Fenwick Solar Project Limited

**Planning Act 2008 – Application for a Development Consent Order for Fenwick Solar Farm**

**Applicant Response to Section 51 Advice Letter dated 29 November 2024**

**Application Ref: EN010152**

**SHEET TITLE**  
TREE PROTECTION PLAN  
(SHEET 1)

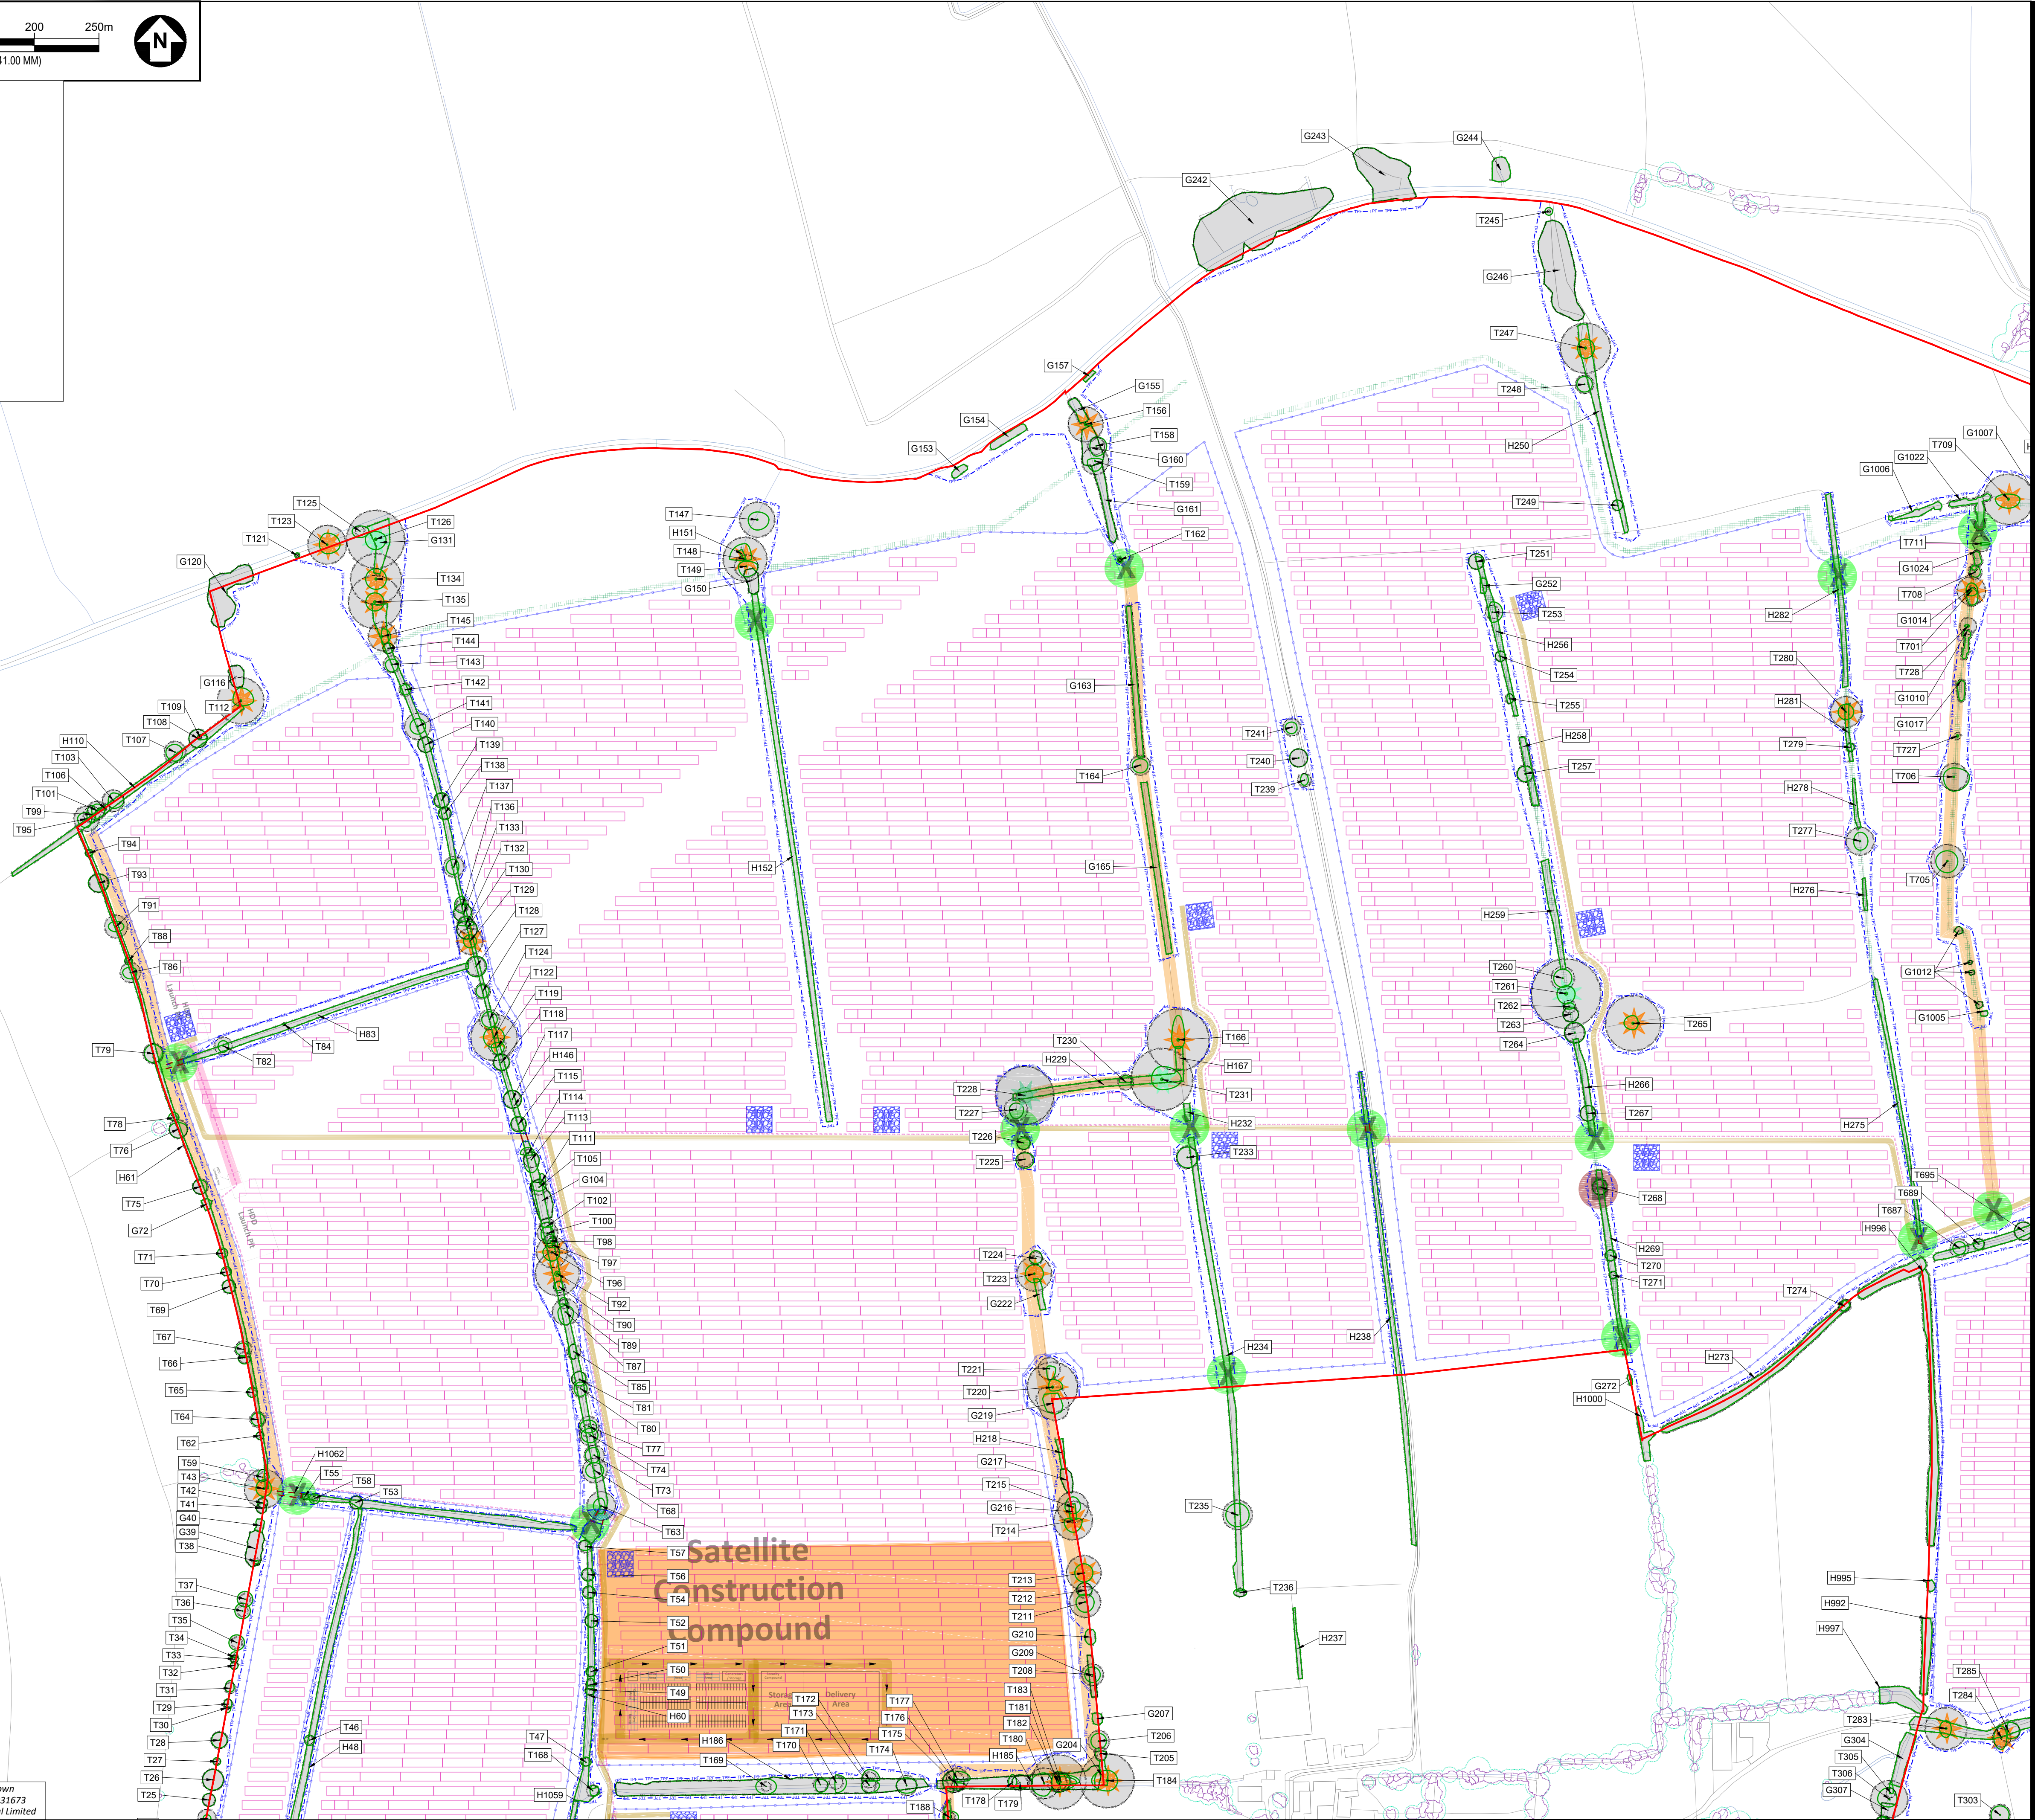
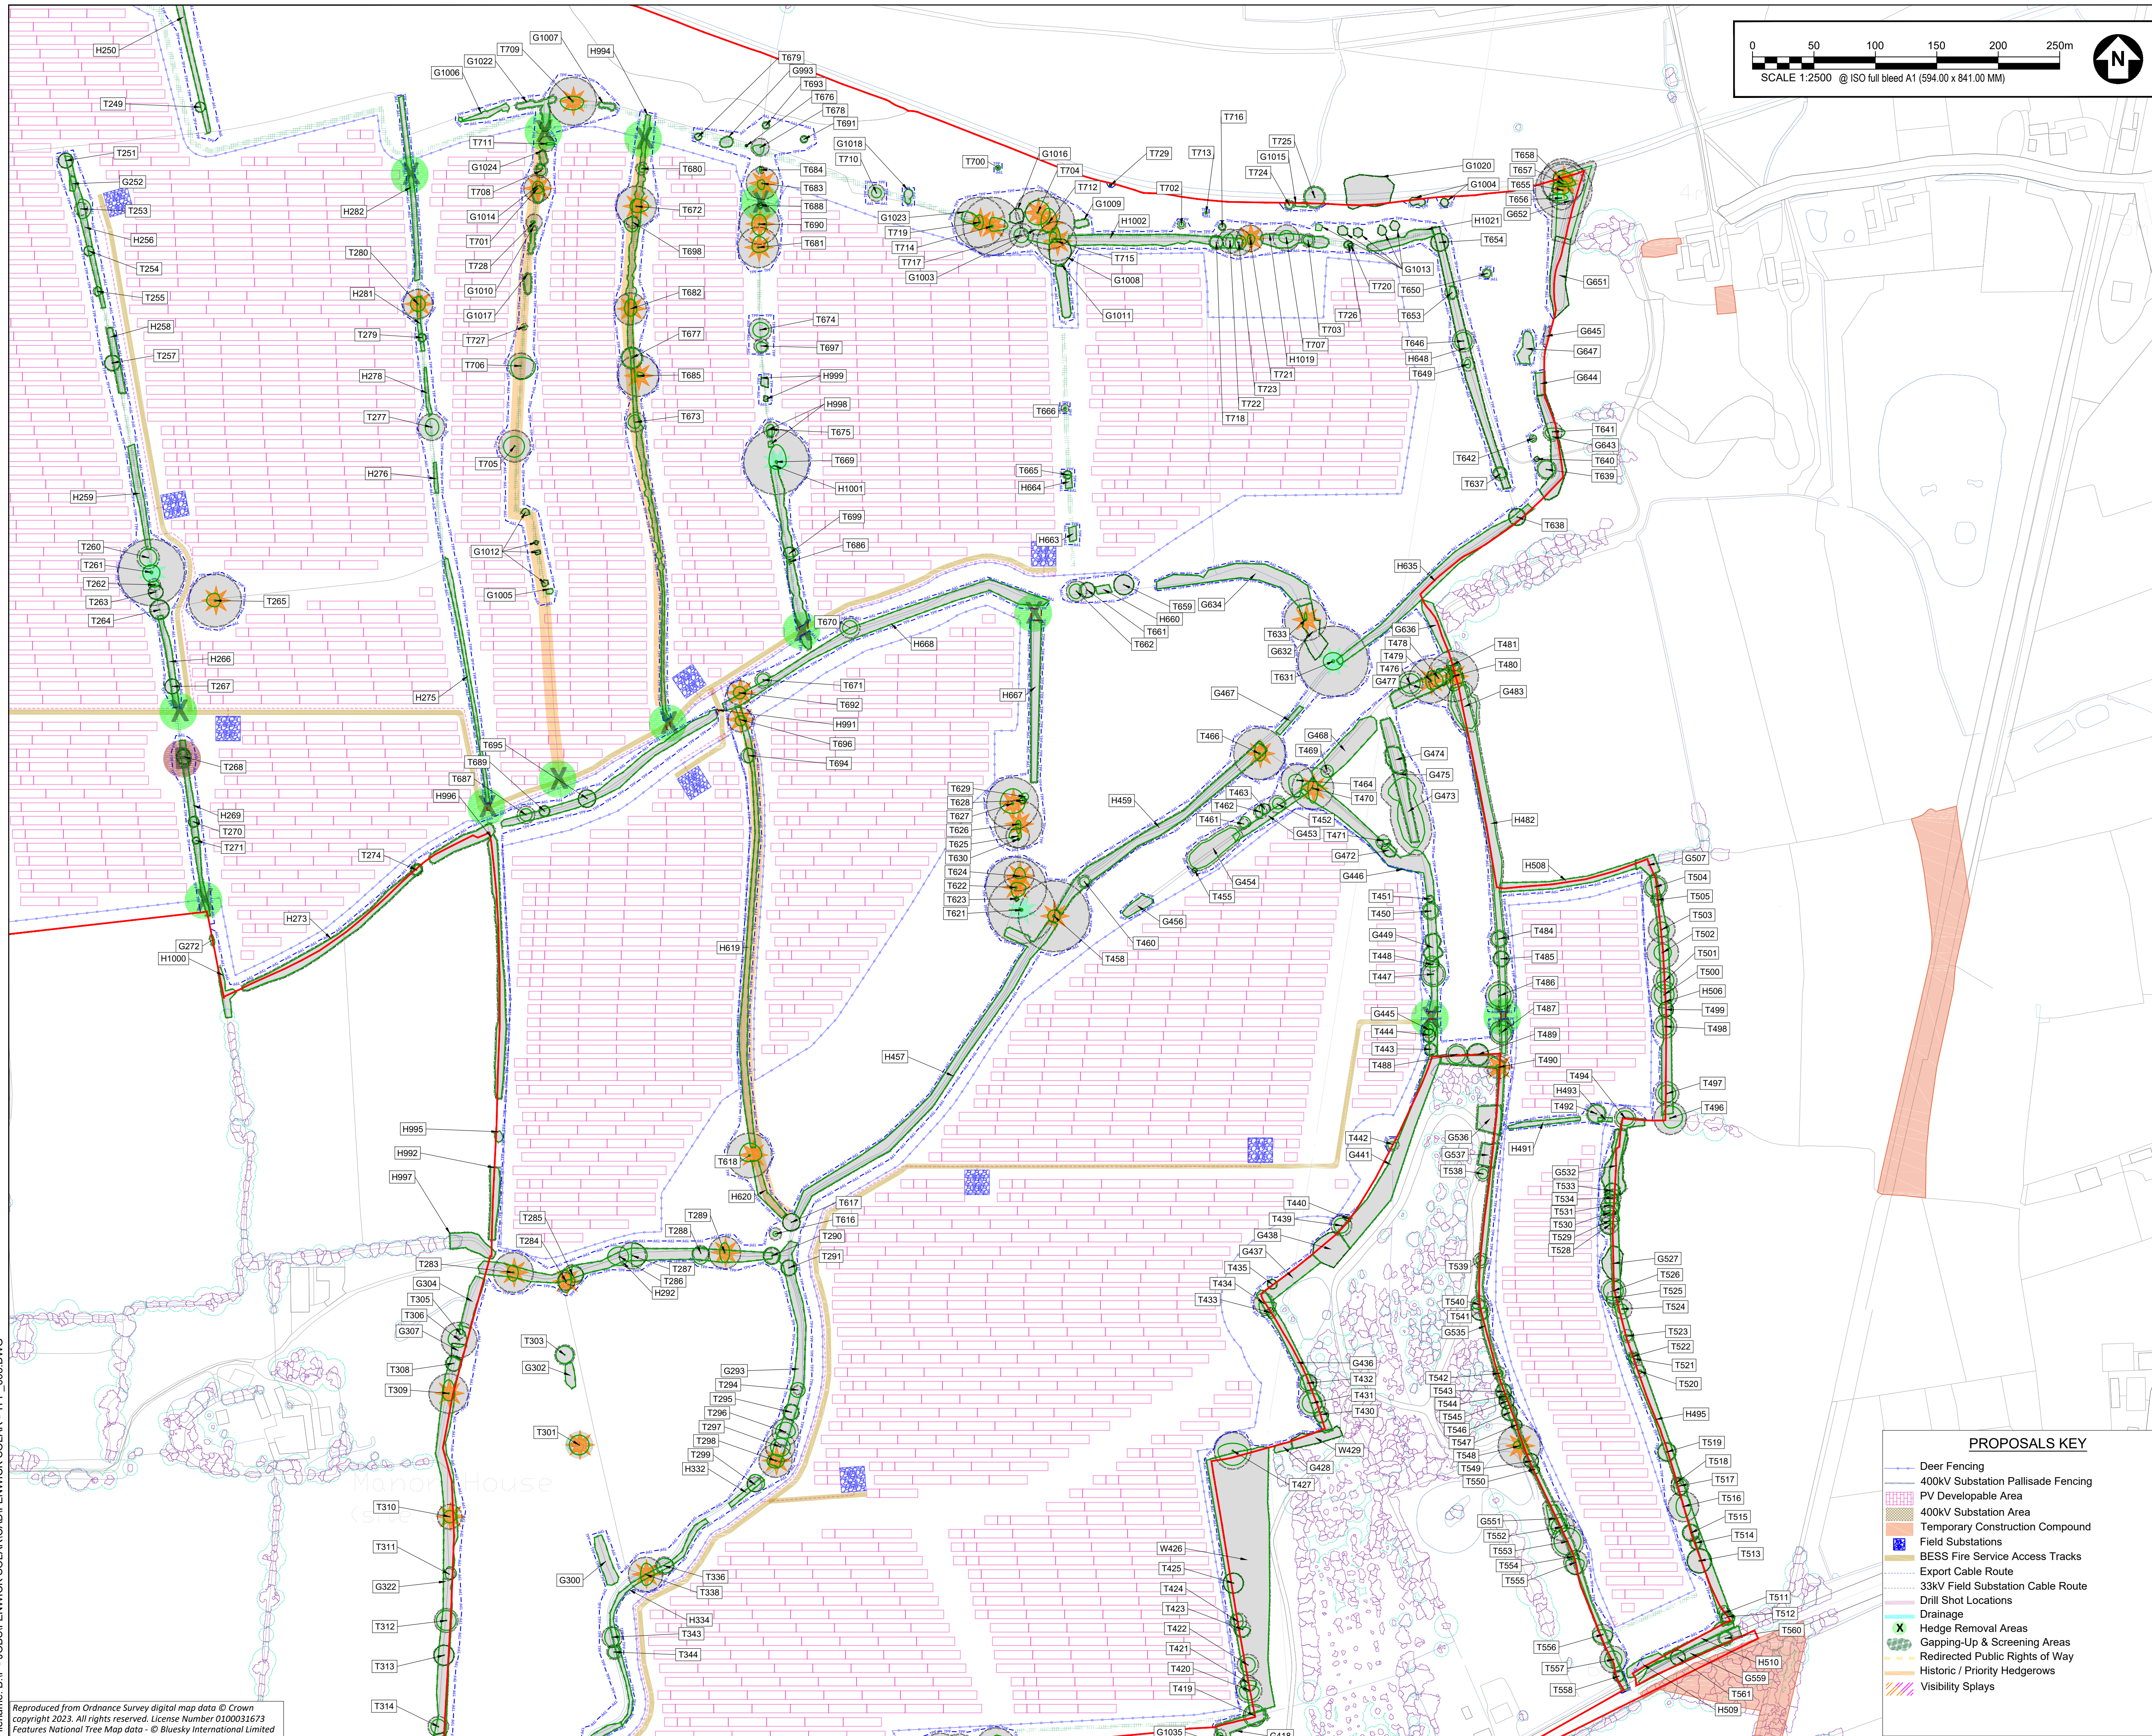
- 1.8.5 **Appendix 10-7: Arboricultural Impact Assessment** (part 1 and part 2) of the Environmental Statement [EN010152/APP/6.3] has been updated by amending the colour scheme of the ancient woodland in both the Tree Constraints Plan and the Tree Protection Plan to provide more contrast between the tree categories and ancient woodland.
